A D D E N D U M

Date May 13, 2005
From Harriman Associates
To Prospective Bidders
Re Addendum No. 1 to the Bidding Documents for:

Maine Heart Surgical Associates
Portland, Maine

BASE PLATE TYPES
 NO SCALE REF: NA **A3**

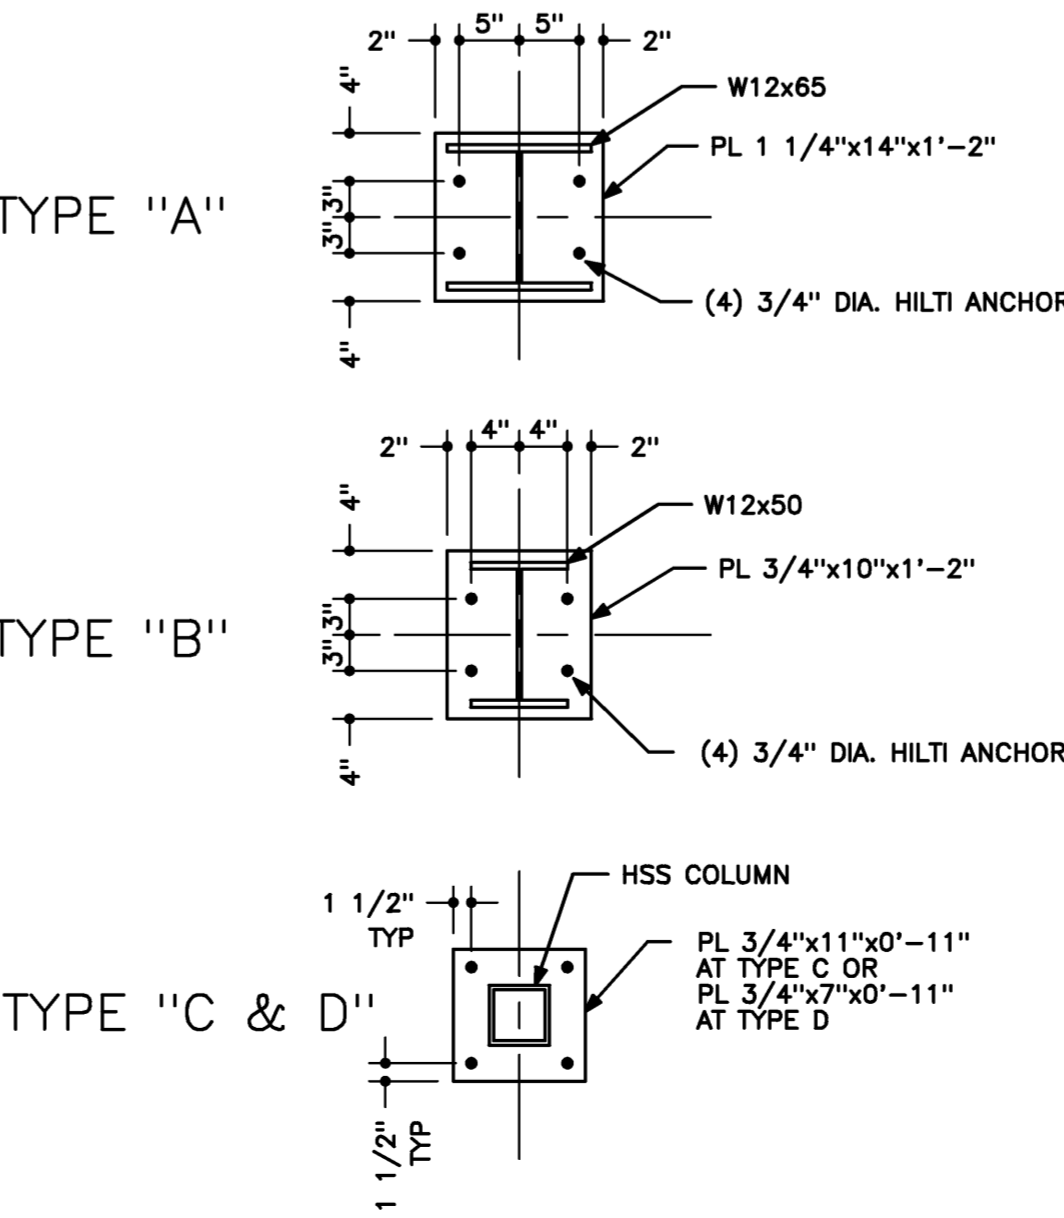
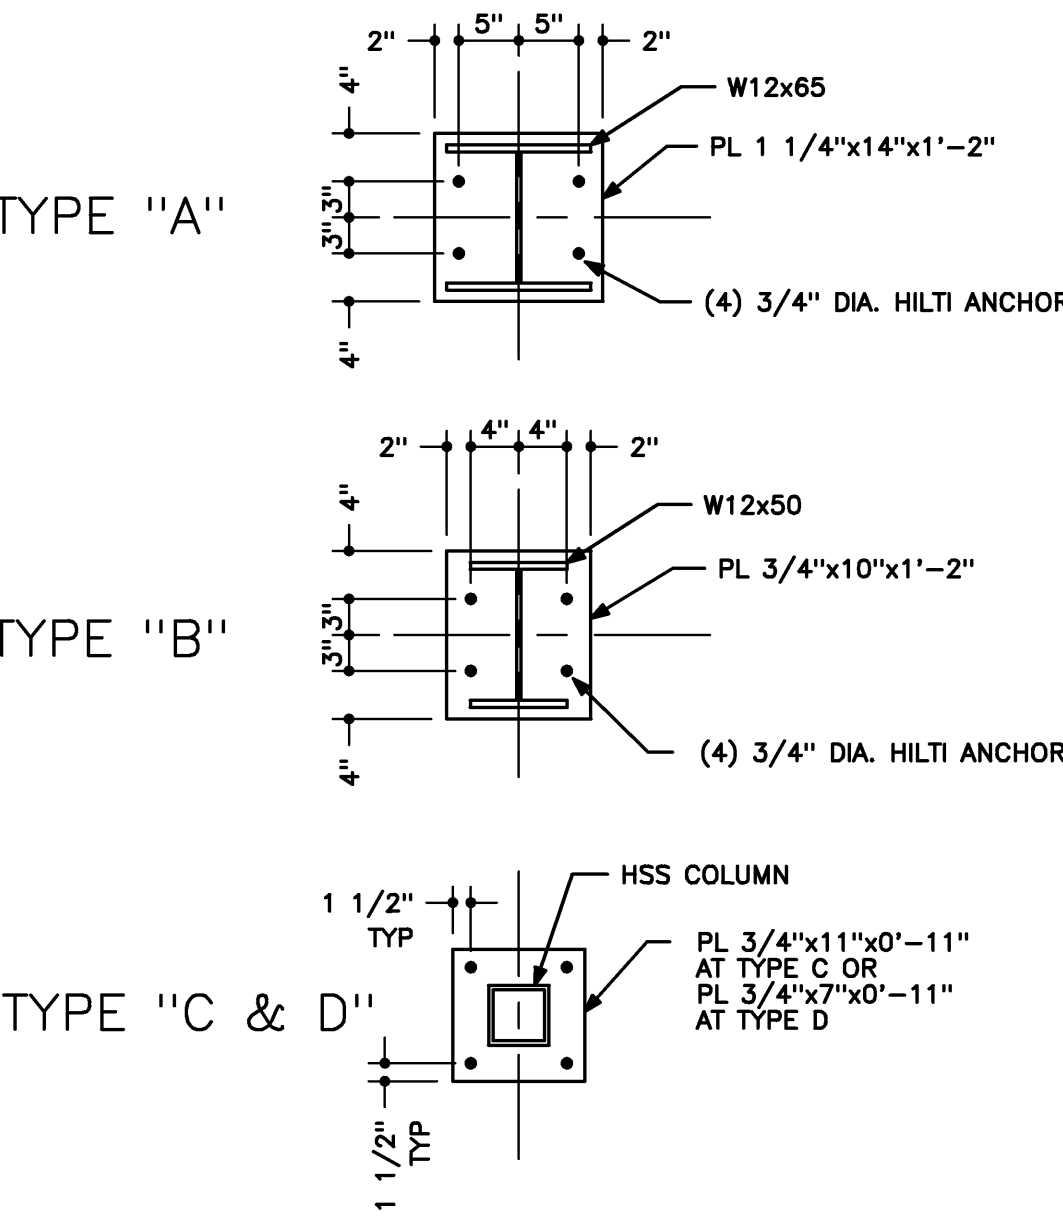
7. DRAWING S60.1 - FRAMING NOTES AND DETAILS
 - a. Detail A3 - Base plate type "C" and "D" - Change text to read "...PL. 3/4x8x0'-11" at type D"
 - b. Change anchor rods for Types "A" and "B" to "3/4" dia. F1554 (Gr. 36) anchor rods - min. embed. = 8"

SECTION C3
 3/4" = 1'-0"
 REF: S20.1

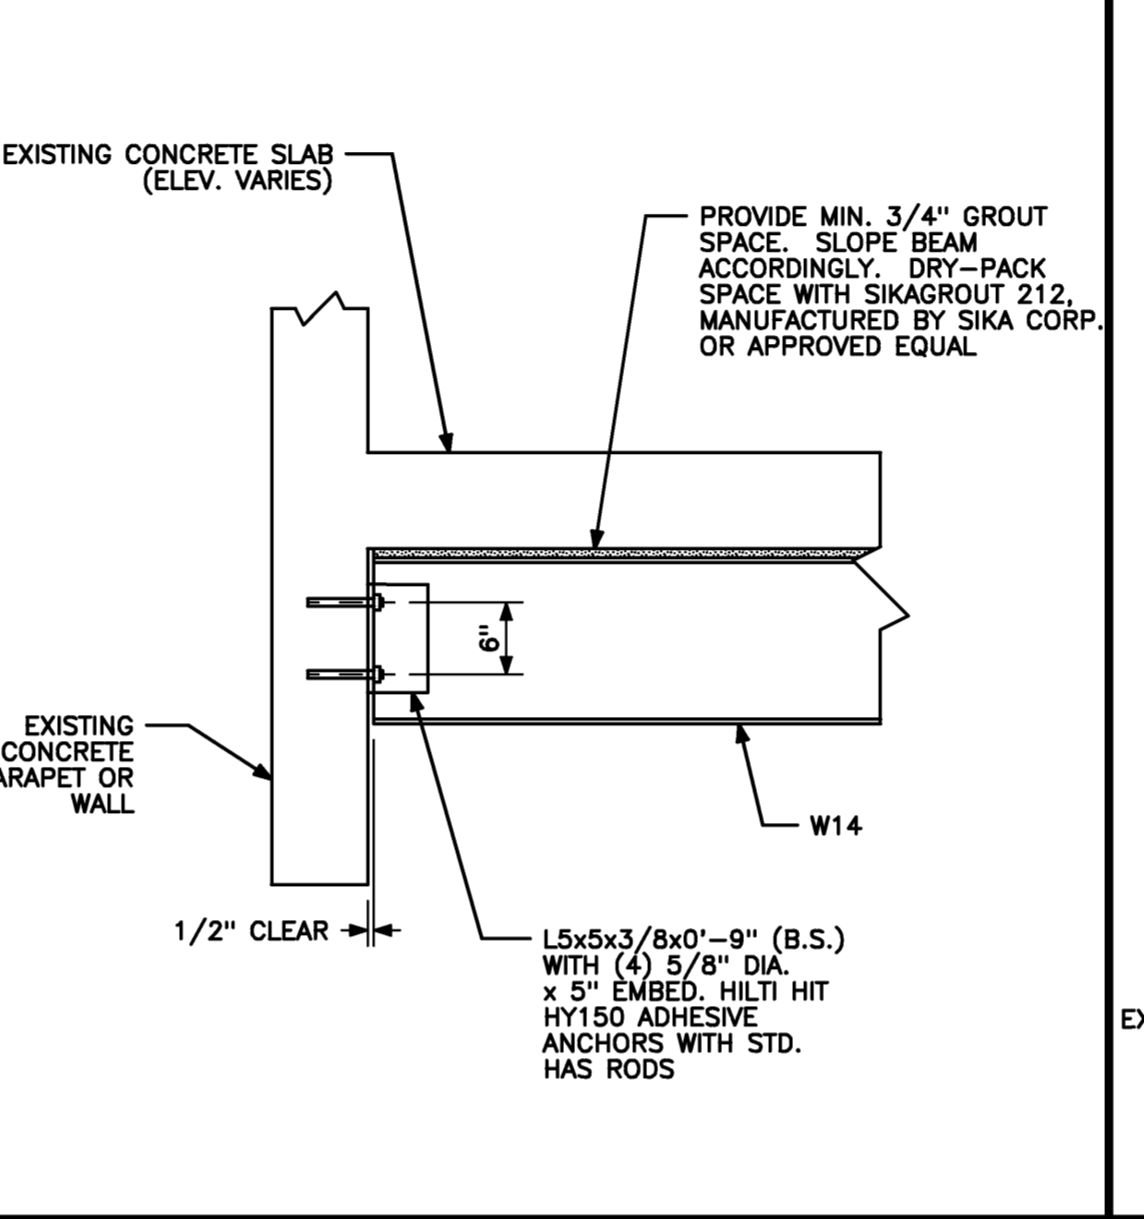
8. DRAWING S60.2 - FRAMING DETAILS
 - a. Detail C3 - Change dry-pack grout note to match detail C2.

TYPICAL SLAB-ON-GRADE CONTROL/CONSTRUCTION JOINT DETAIL **C3**
 NO SCALE REF: NA

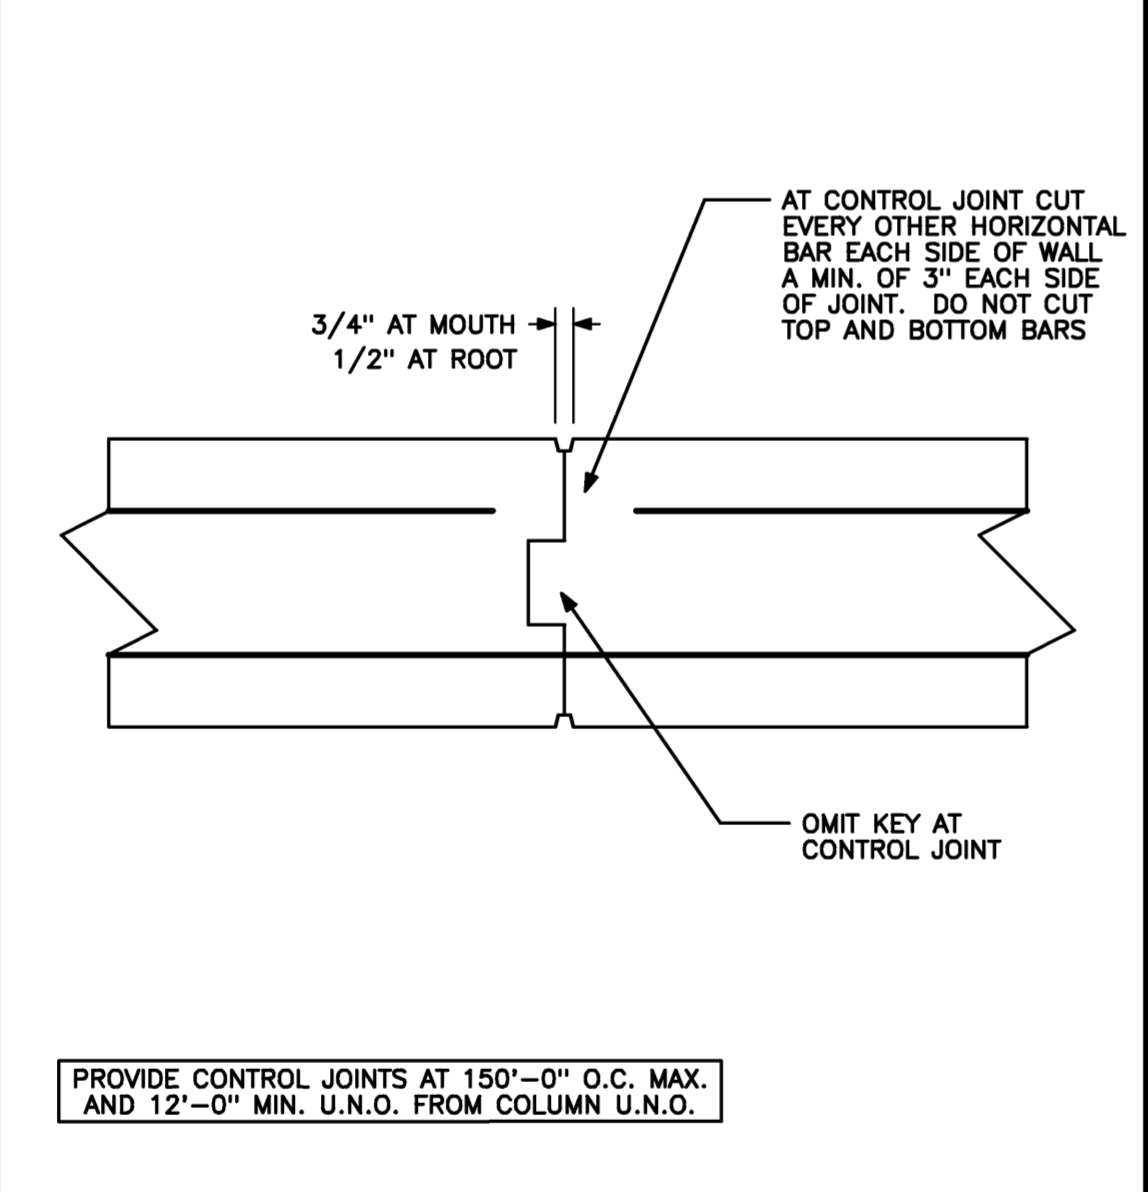
5. DRAWING S50.1 - FOUNDATION NOTES AND DETAILS
 - a. Detail A2 - Add dimension from top of slab to bottom of haunch = 1'-0"
 - b. Detail C3 - Change note at control joint to read "Sawcut to 1/4 of the slab thickness".
 - c. Detail C6 - Change note to read "... Holes shall be used in conjunction with dowel locations. Additional holes are permitted for grouting, provided they are filled to the top of slab".
 - d. Detail D1 - Delete note #3. Add vertical reinforcing in column surround - "(4) #5 vert."
 - e. Detail D2 - Add #6 bar at back of pier on column centerline, and change note to "(6) #6 vert".
 - f. Detail D4 - See SKA03
 - g. Detail D5 - Add #7 bar at back of pier on column centerline and change note to "(6) #7" Add #4 straight ties @10" between two dowels on column centerline (hook ends).
